To: All Staff
From: Environmental Health
Date: 6/25/2026
Subject: SP-26-00005 Ridgeway

RIDGWAY SHORT PLAT

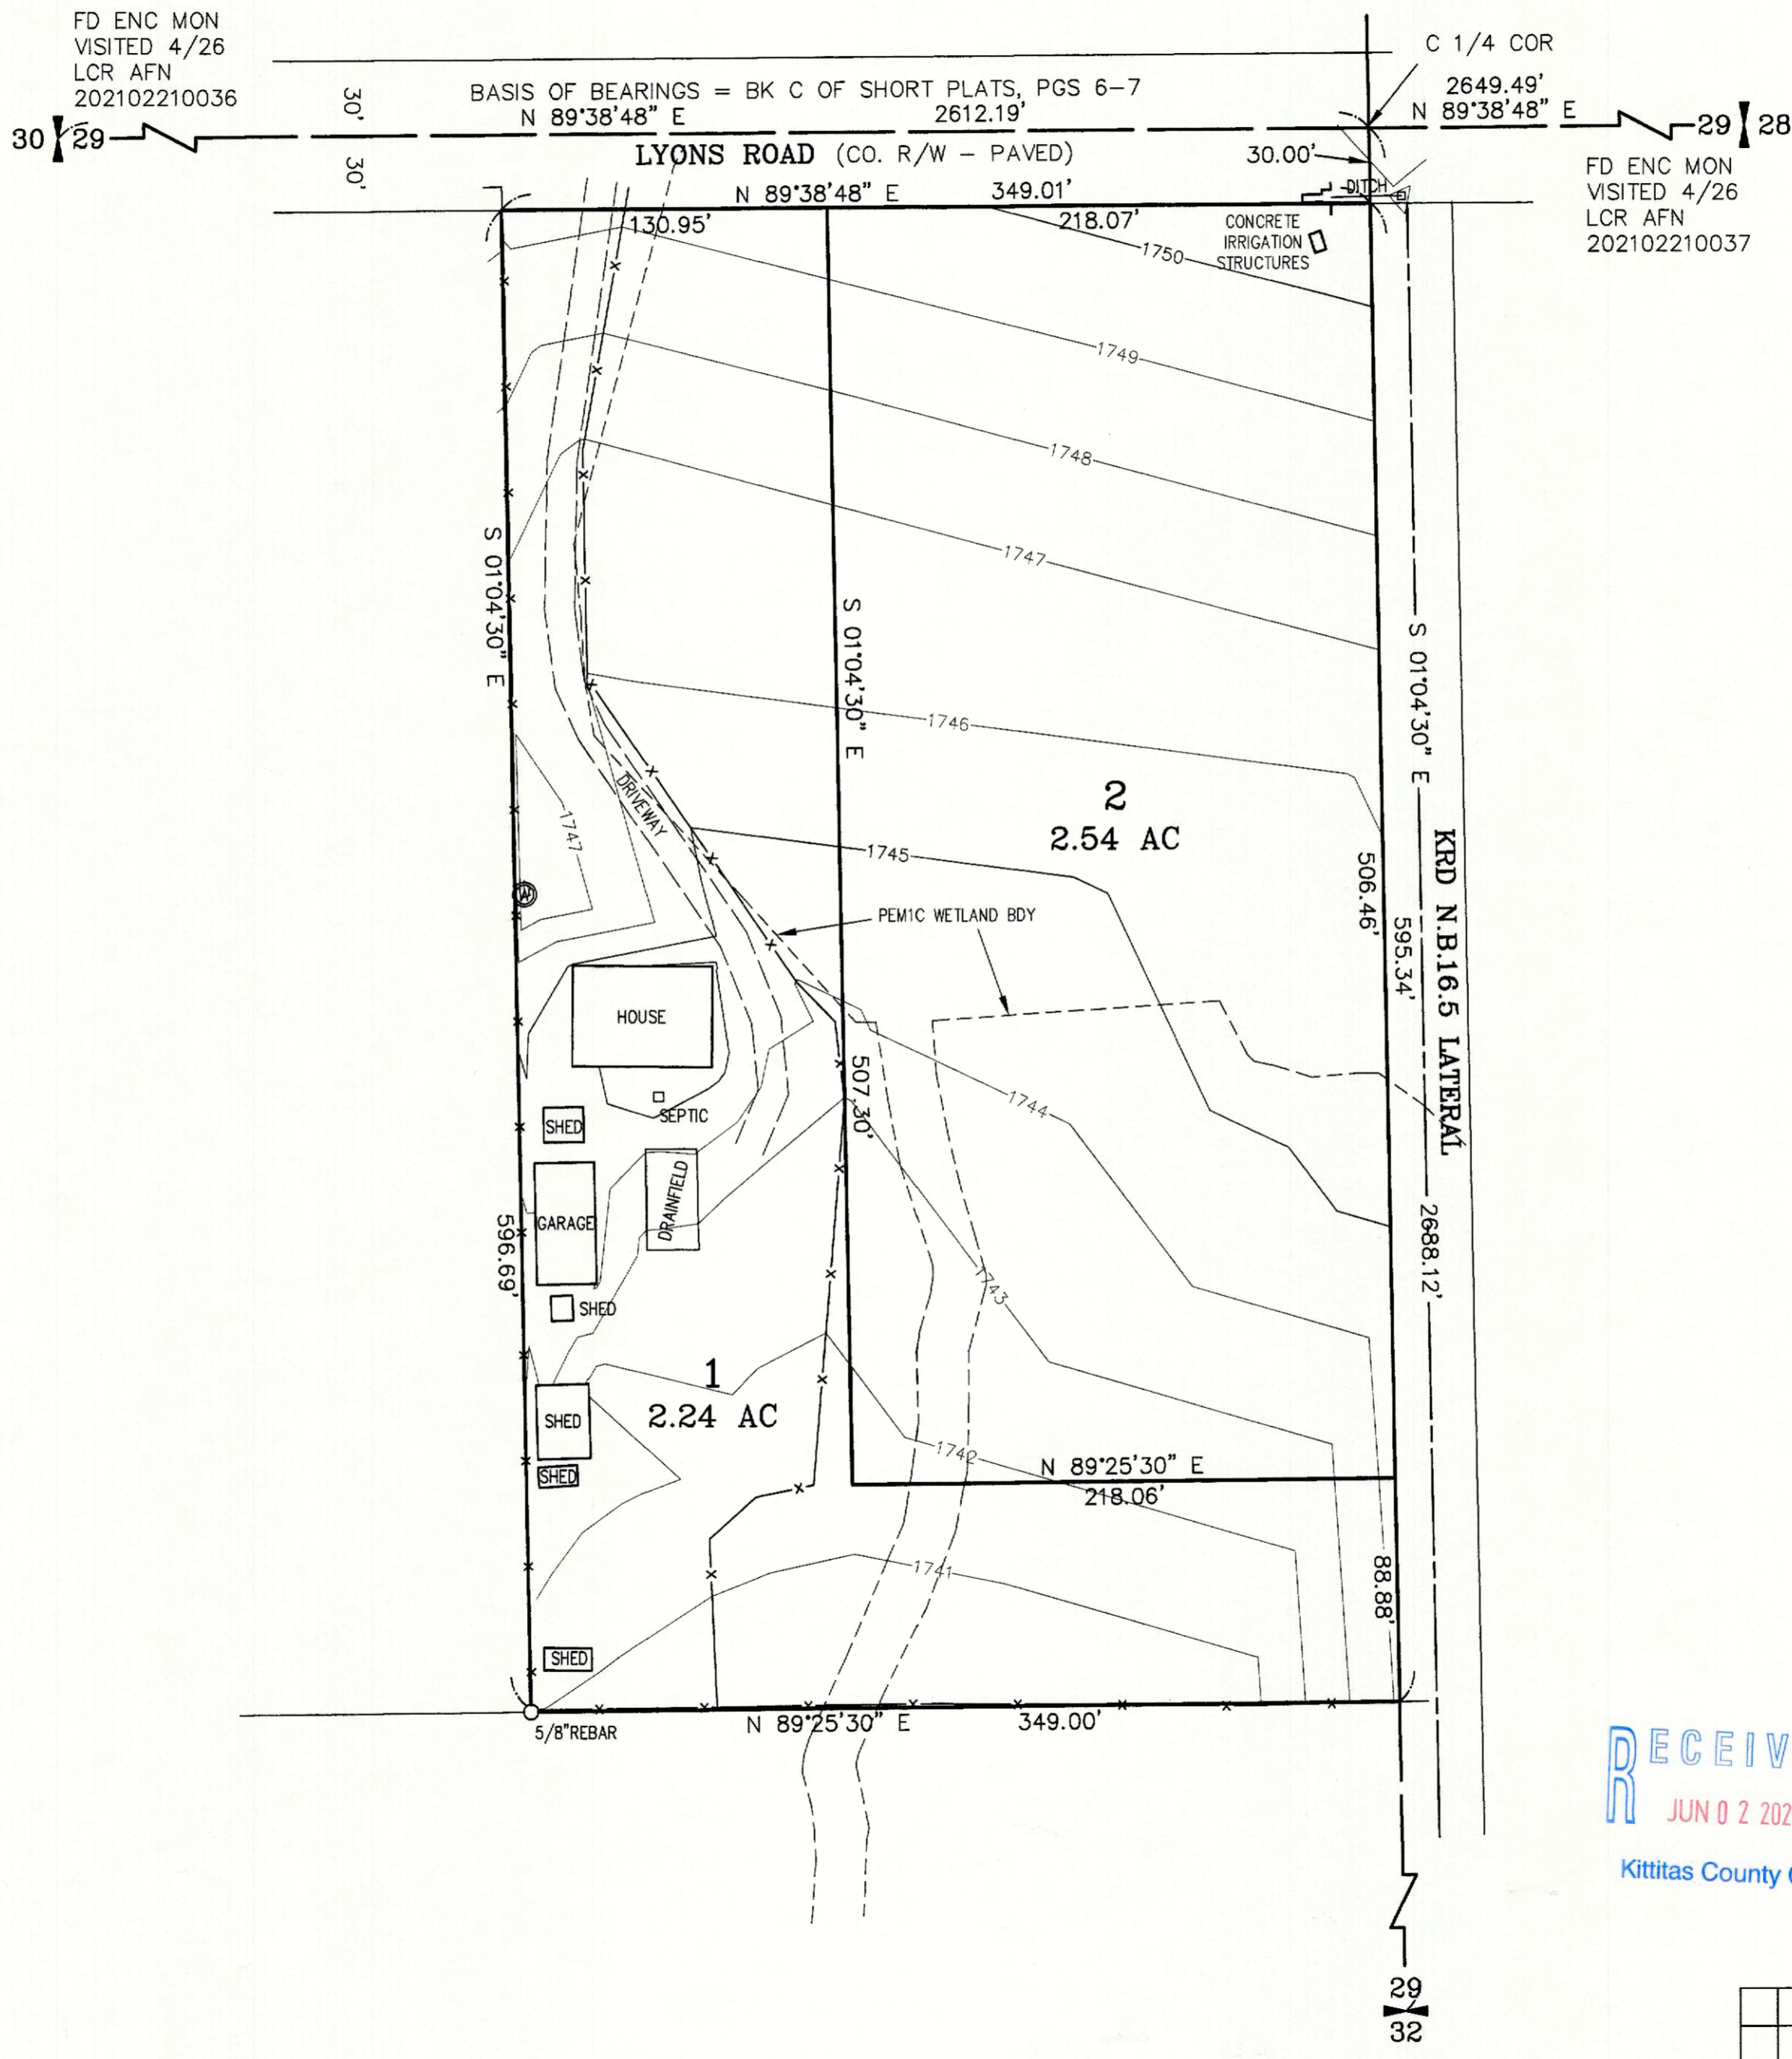
Wastewater	• Prior to preliminary plat approval, the applicant shall perform soil logs in accordance with KCC 13.08.040 to demonstrate that the proposed lots can support conforming on-site sewage systems and required reserve areas. The evaluation shall include a minimum of two soil test pits per lot within the primary and reserve drainfield areas, and the test pit locations shall be shown on the plat map and flagged in the field for inspection.
